Phone: 0300 123 6780
Email: developeras@lancashire.gov.uk
Your ref: 3/2025/0386
Our ref: 3/2025/0386/HDC/KW
Date: 02 June 2025

Location: 3 Hayhurst Road Whalley BB7 9RL
Proposal: Two storey extension with a single storey link building.
Grid Ref: 373331 436716

2 PROPOSED SITE PLAN  
1 : 100

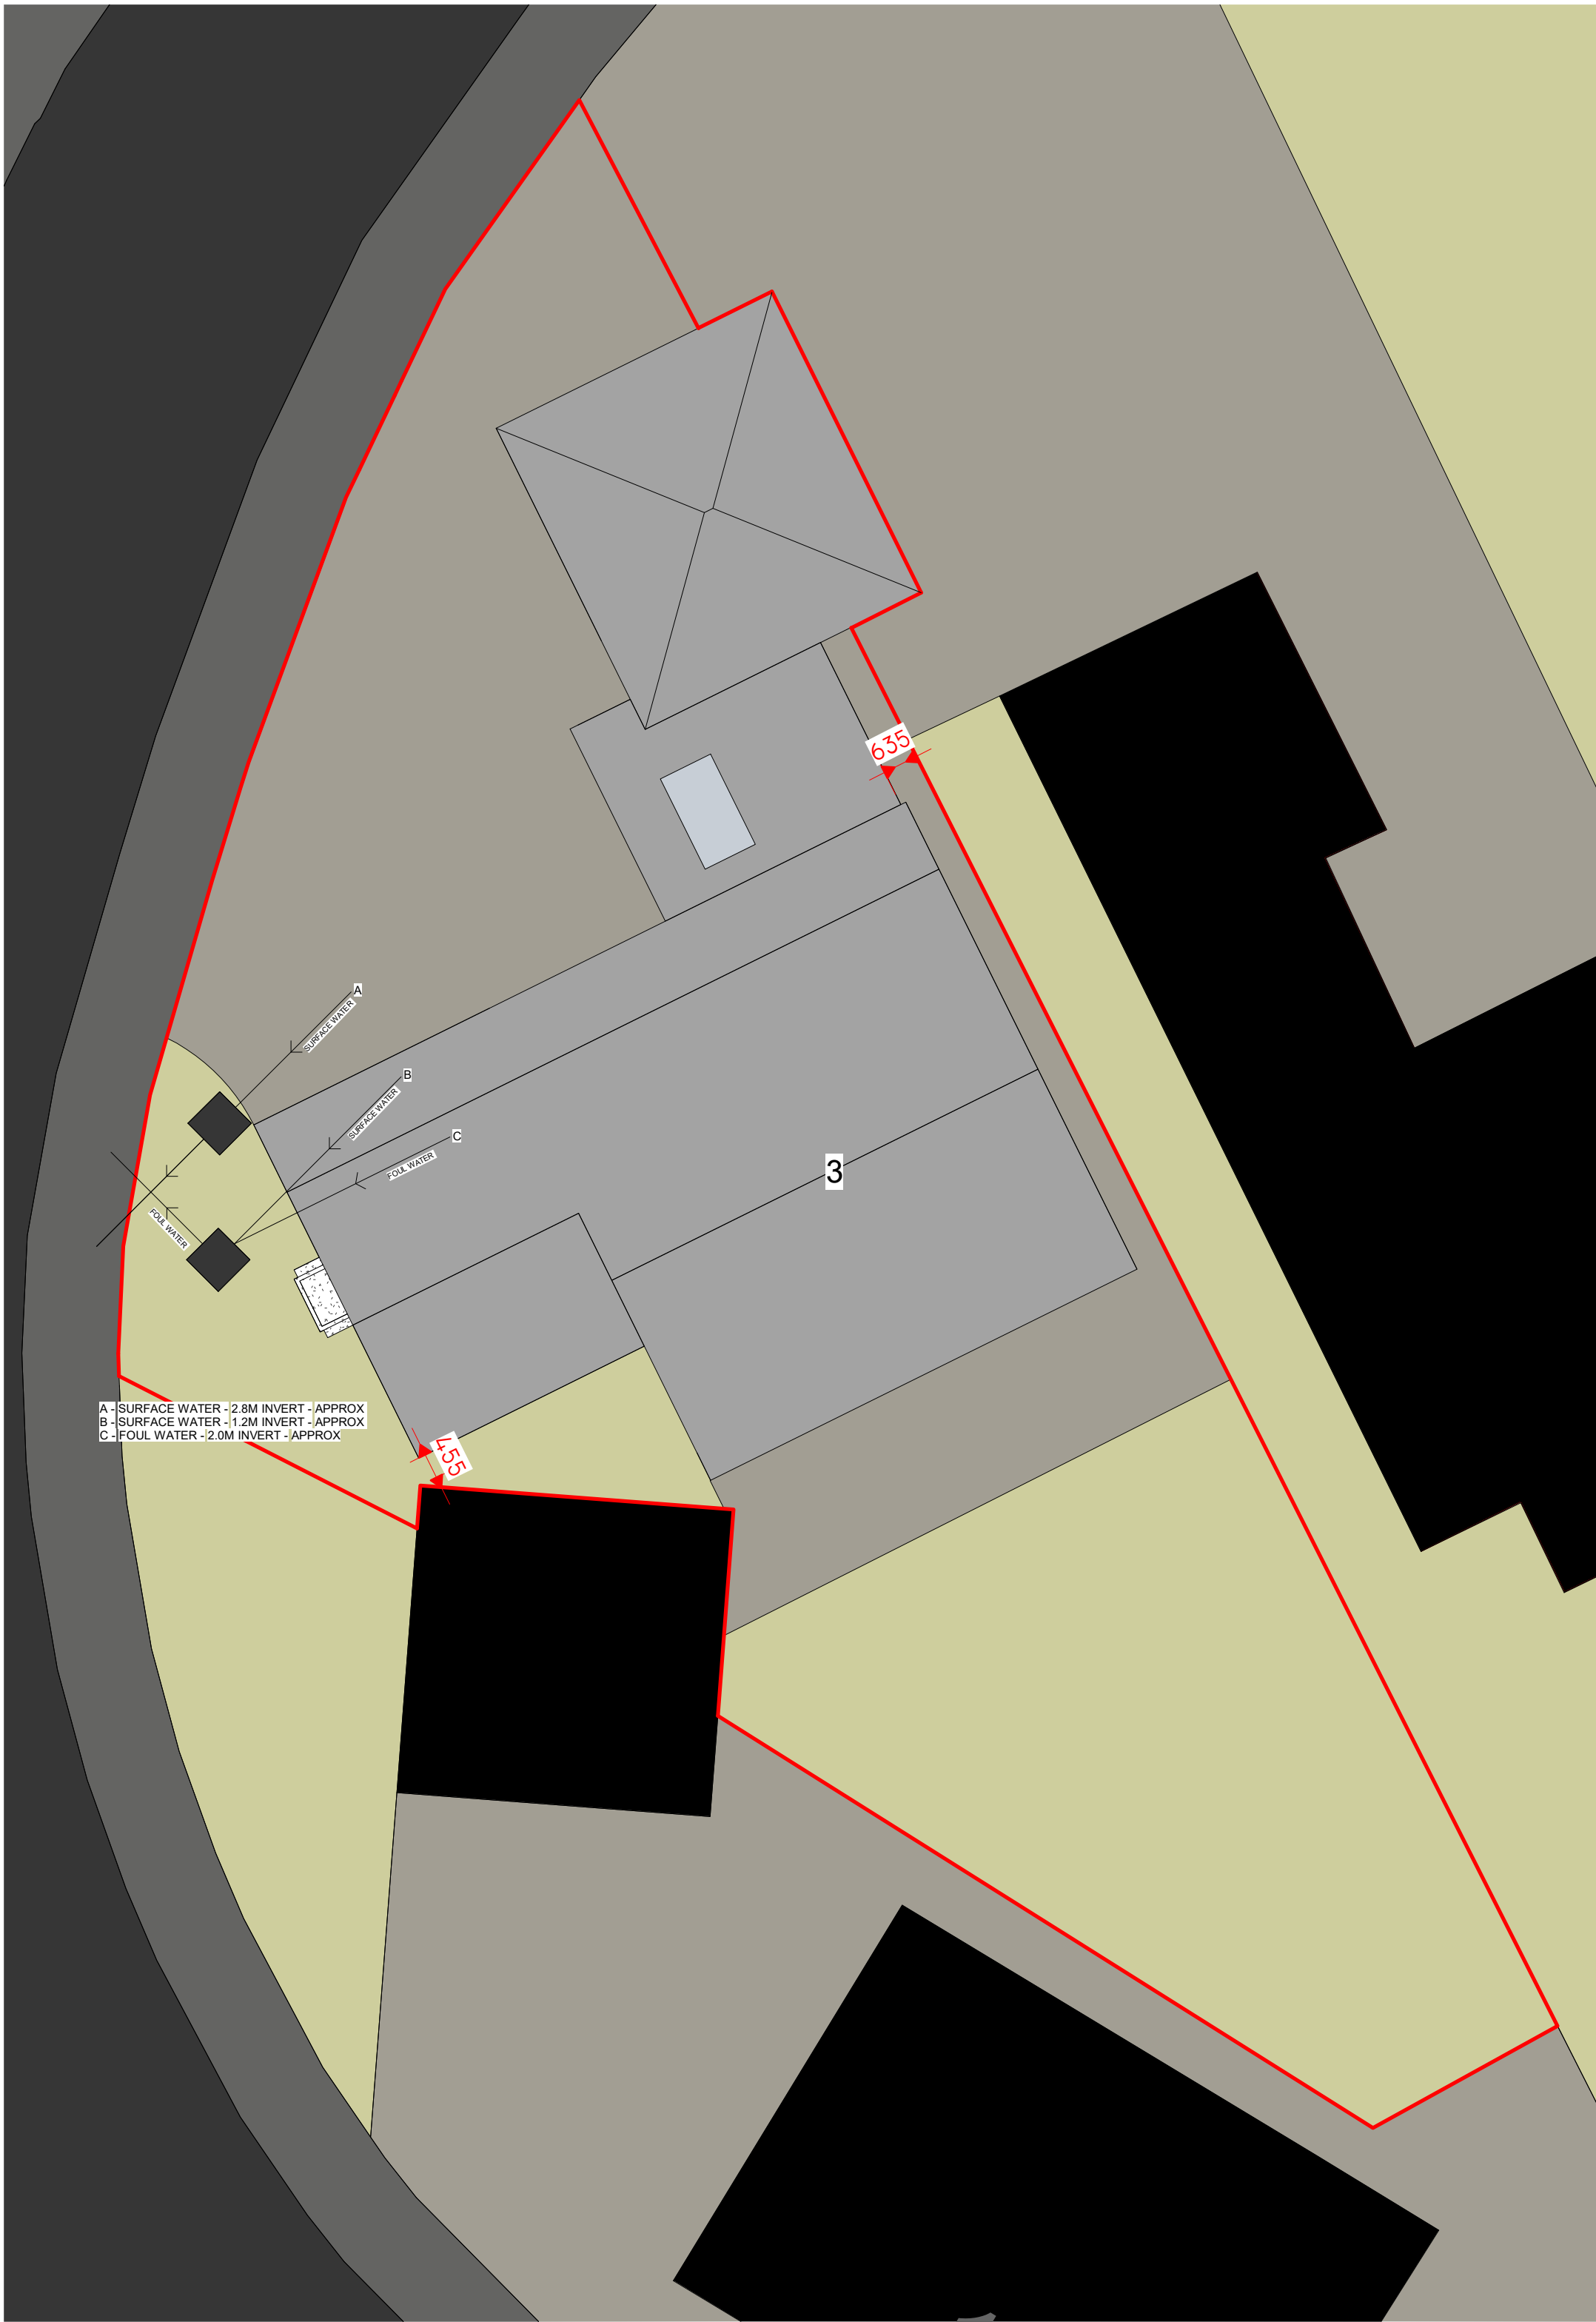
The alterations to the garage will reduce its internal dimensions and as such the proposed garage does not comply with the LHAs guidance, which is 6m by 3m for a single garage. As such, only 2 off street parking spaces can be provided within the site.

Notwithstanding this, the LHA will accept the shortfall in parking at the site. This is because the existing double garage also does not comply with the LHAs guidance as such, the dwelling is retaining the existing number of bedrooms and the existing parking provisions, causing the LHA to accept the shortfall in parking and having no objection to the proposal.
